Application for a Non-Material Amendment Following a Grant of Planning Permission

Land to the East of Shripney Road Shripney PO22 9NW

~~outline application for up to 40 dwellings together with access, with all other matters reserved.~~
VARIATION OF CONDITION FOLLOWING APPROVAL OF BE/61/23/RES RELATING TO
AMENDED ARBORICULTURAL IMPACT AND METHOD STATEMENTS (CONDITION 2)

Detailed Planting Plan 1 of 3

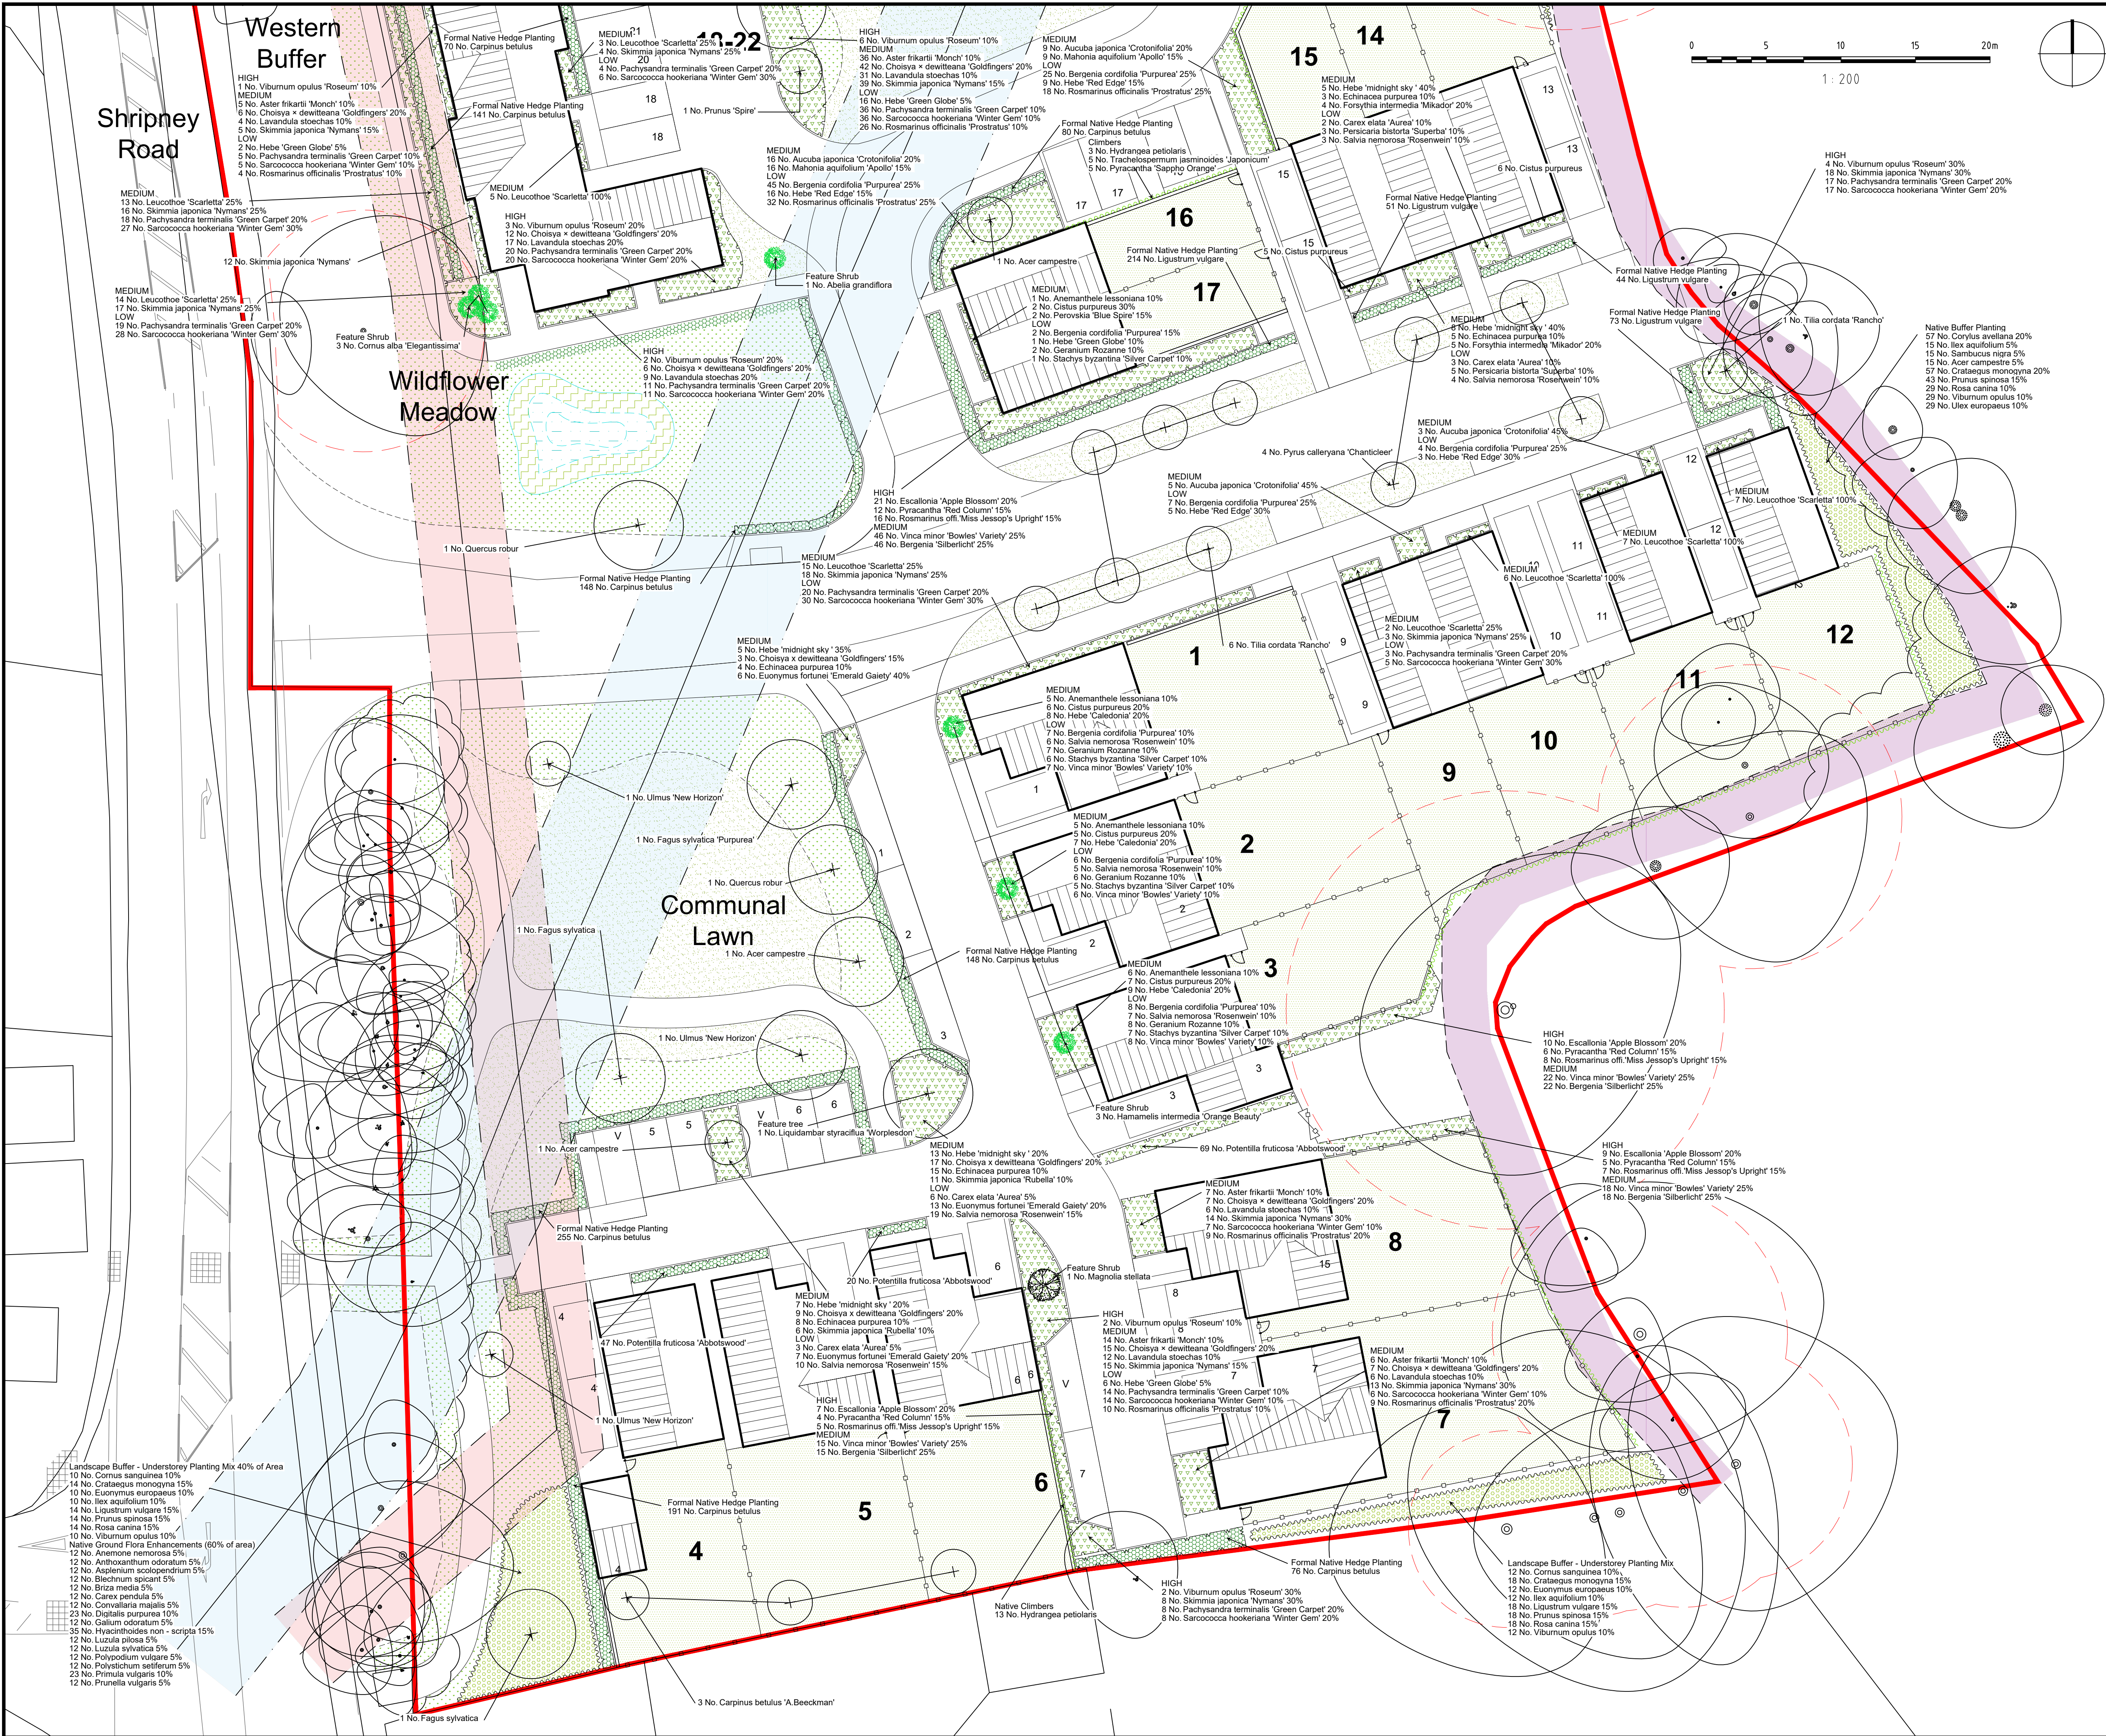
The proposed amendment relates to changing the specification of grass to the rear gardens of properties from 'Proposed lawn to back gardens – Naturescape N14 Flowering Lawn Mixture or similar' (as approved) to 'Proposed amenity lawn to back gardens using high quality turf - Rowlan Medallion or similar' (as proposed).

- DD598L03 Rev A Detailed Planting Plan 1 of 3
- DD598L04 Rev A Detailed Planting Plan 2 of 3

- DD598L03 Rev C Detailed Planting Plan 1 of 3
- DD598L04 Rev C Detailed Planting Plan 2 of 3
